REF: 23/01586/REM

Location: Proposed Himley Village North West Bicester,
Middleton Stoney Road, Bicester

Holding objection

HIMLEY VILLAGE, BICESTER – BOUNDARY TREATMENTS PLAN

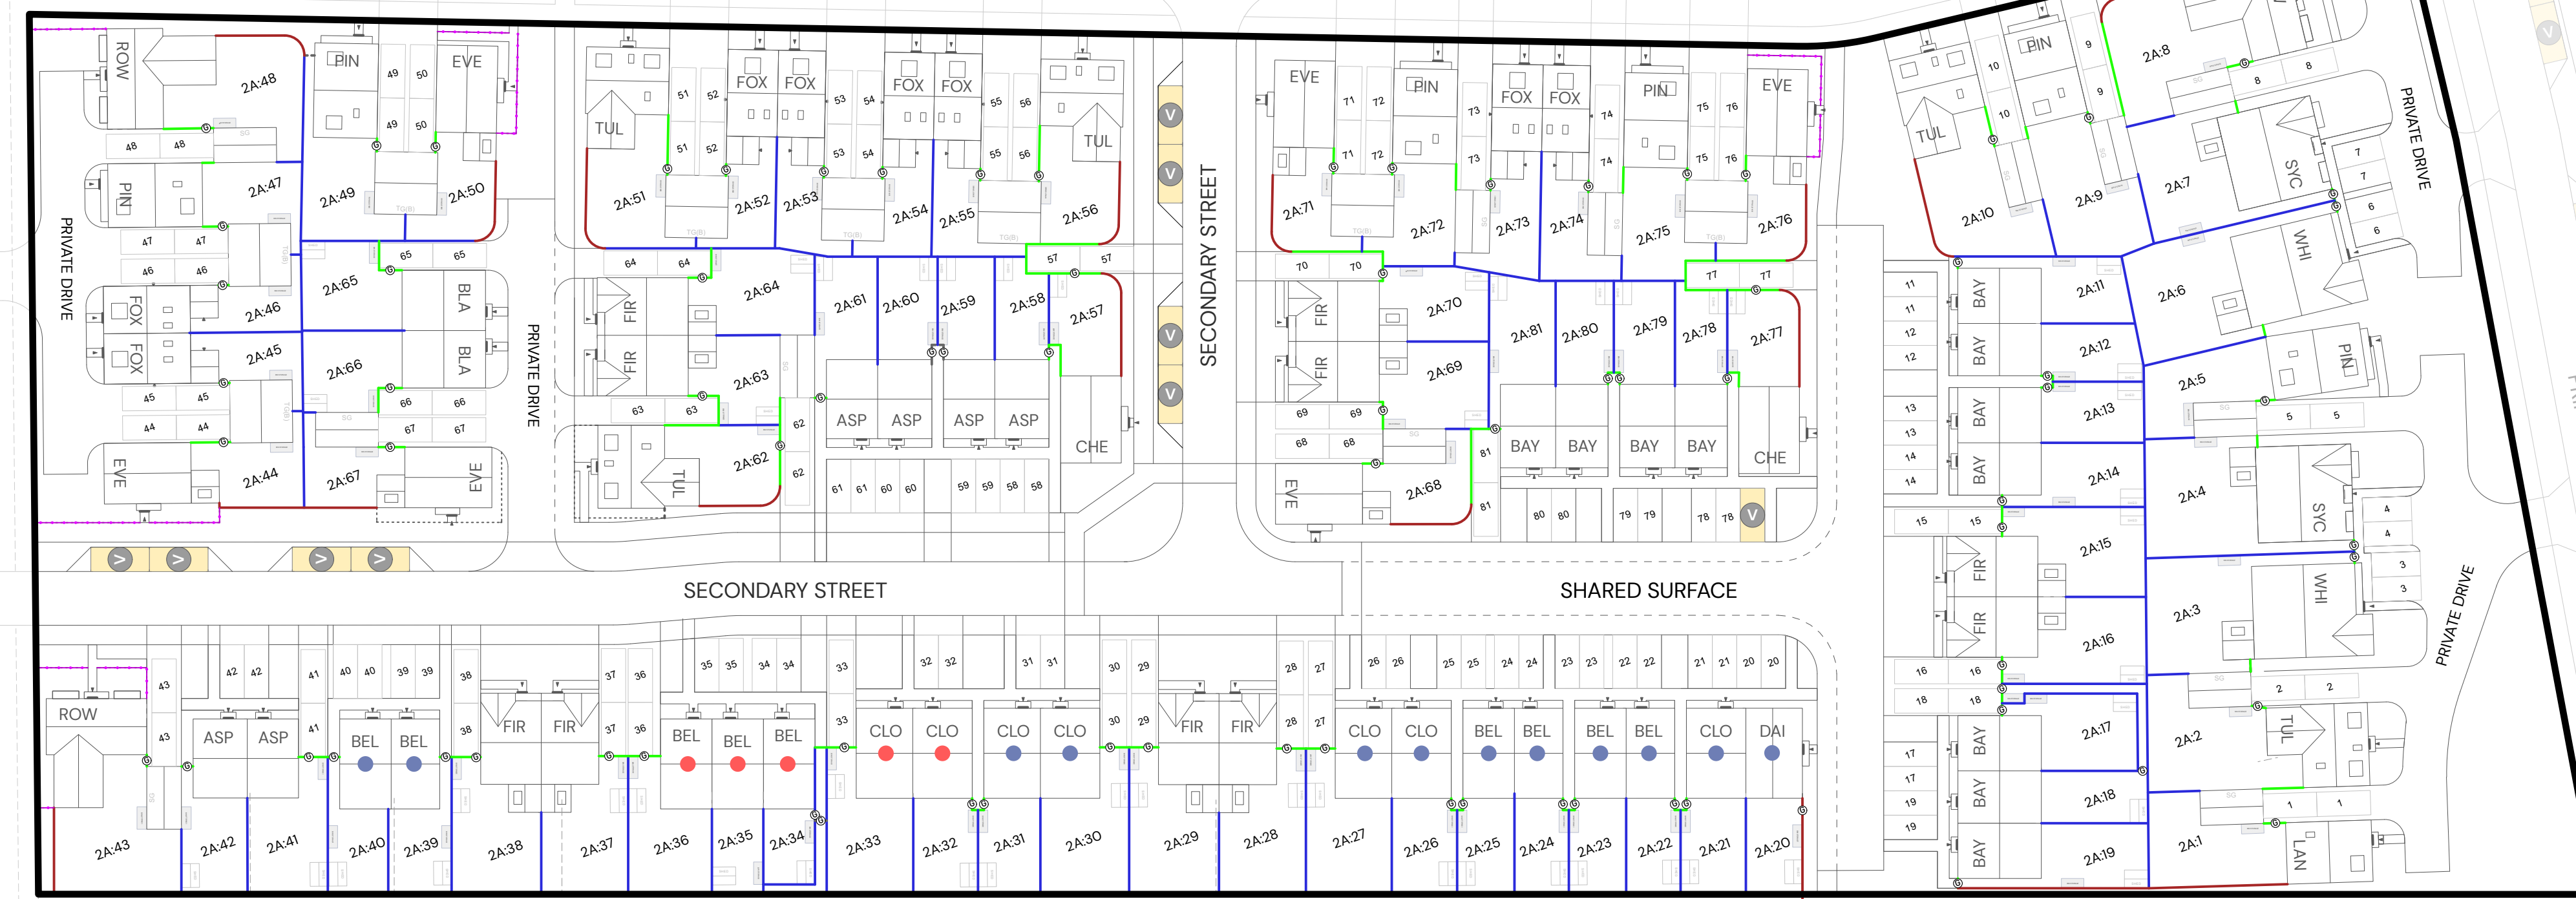
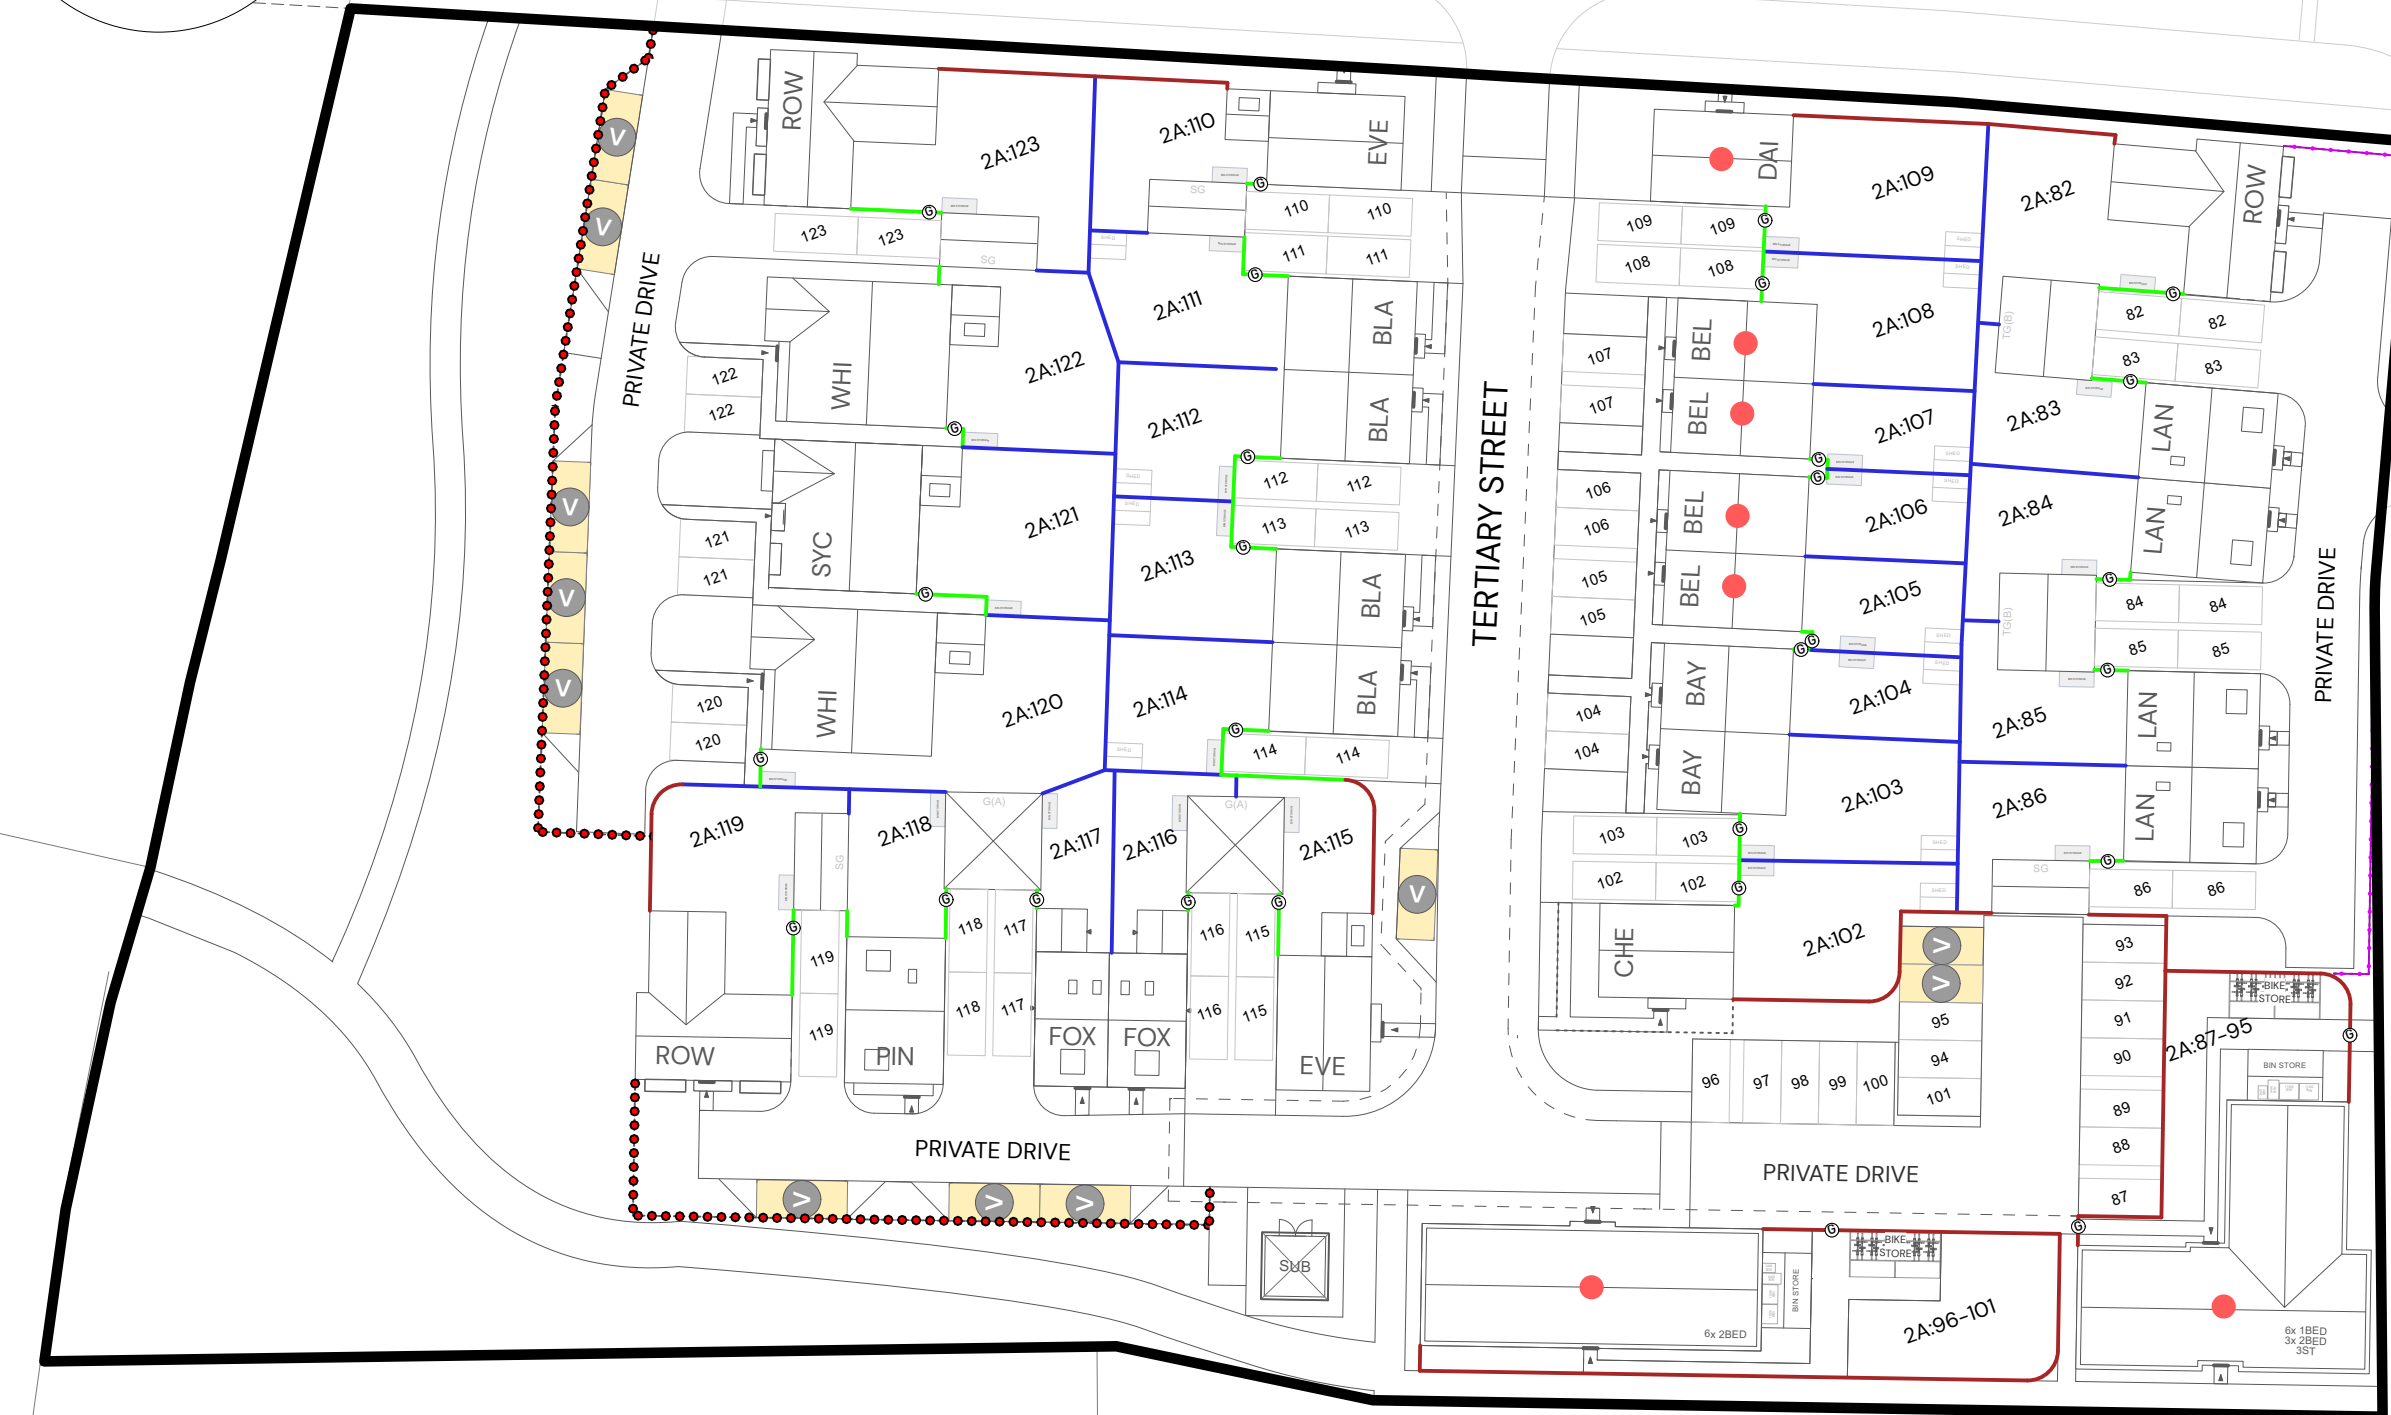
Current proposals for garden access leave this development vulnerable to high impact crime such as burglary, and creates spaces where crime and antisocial behaviour may flourish. All rear access routes must be secured to the front of the building line, and secured with a robust key operated lock operable from both sides. The boundary treatments enclosing rear access routes should be of suitably robust construction, and I ask that larch lap fencing is changed to closeboard fencing. I ask that additional gates are added across the development to secure rear access routes, as demonstrated below;

- Parking spaces to the rear of dwelling gardens are at higher risk of crime and ASB due to reduced visibility over cars from the dwellings that they serve. Where this is unavoidable, the boundary treatment enclosing parking should be designed to enable surveillance – I ask that 1.5m close board fencing with a 0.3m trellis topper is used to provide views over parking from the garden of the plot that it serves.

HIMLEY VILLAGE BICESTER – APARTMENT A1 ELEVATIONS

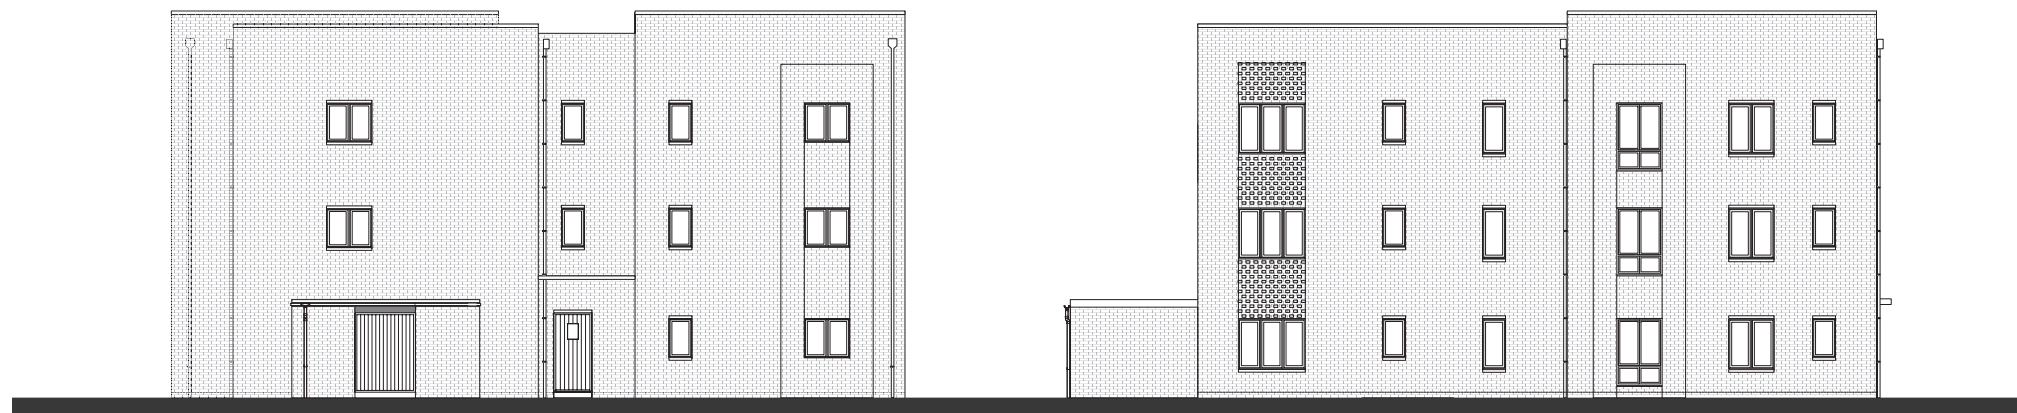
The security arrangements of apartment blocks should follow the best practice recommendations of Secured by design, and details of proposed building security arrangements including access controls and secure mail services should be included within the application. Unrestricted access to apartment blocks should not be possible, and residential access should be controlled by a two-way audio visual system with remote access controls. No trade button should be present. A secure lobby should be provided to all communal entrances. Postal services should not have unrestricted access to private communal areas, and mail delivery should be provided within a secure lobby at the entrance to the building, or via “Through the wall” letterboxes.
